PLANNING APPLICATION N°
2025/62/92206/E

APPLICATION. DEMOLISH OF EXISTING DWELLING
AND ERECTION OF FIVE DWELLINGS, WITH ASSOCIATED e
At 42. ROBIN ROYD LANE MIRFIELD WF14 0LG

TYPE OF COMMENT: AN OBJECTION

PROPOSED SW ELEVATION

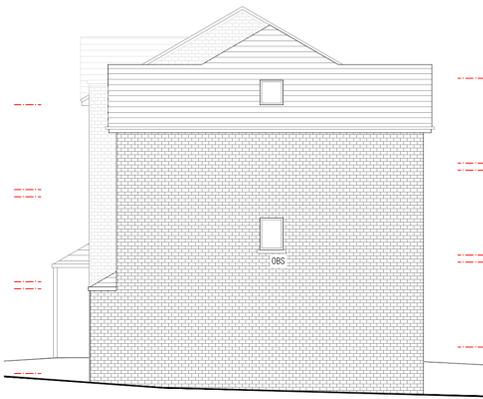
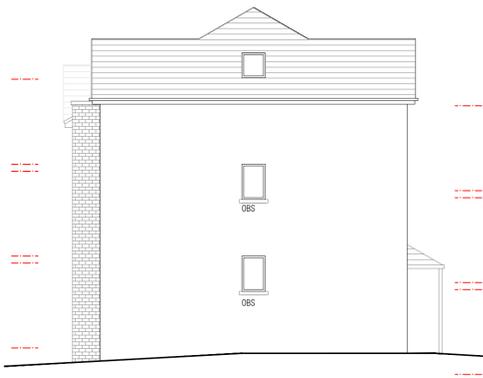
When N°42 is demolished the plans
do not show how house gable is to
be finished.

Regards the layout of the proposed site this would deliver 5 cramped house of 3 story high blocking light to ever angle and of no characteristics to existing properties.

The layout would present with a 3 story gable (containing windows) approx. 4 Foot from perimeter, extending almost the length of the garden, blocking all

3. light and eliminating an open aspect that enjoy now. This is caused by hideous tandem parking proposal, pushing the house line further back from the road. P3

PROPOSED BLOCK PLAN 1:200

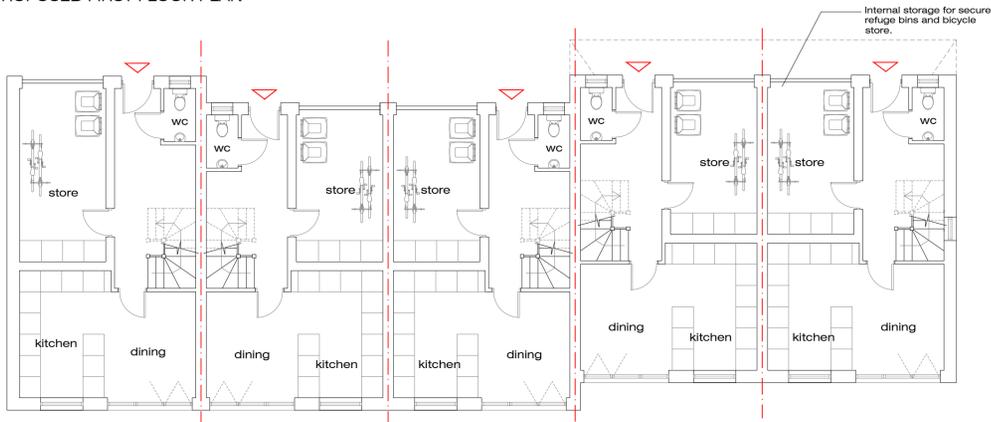
May I point out that when referring to site
Plans, N°42 R.R.L is to be demolished, this
is the house attached to N°44.R.R.L.

The site plans show a N°46 which has not
existed for 45yrs. When it became N°44 inc.

2/ The position of the site is within 30mtrs of the remainder of R.R.L, a blind P2 Cul de sac with No turning point. This 30mtr length x 5mtr wide lane already struggles to serve 5 houses, and access to farm fields (requiring daily access), accompanied with visiting cars and deliveries this renders the area saturated, further vehicular use would render the lane untenable, causing danger to daily pedestrians as a busy school route.

The North side of R.R.L now accommodates 4 houses. Placing 6 houses at the South side is too compactable.
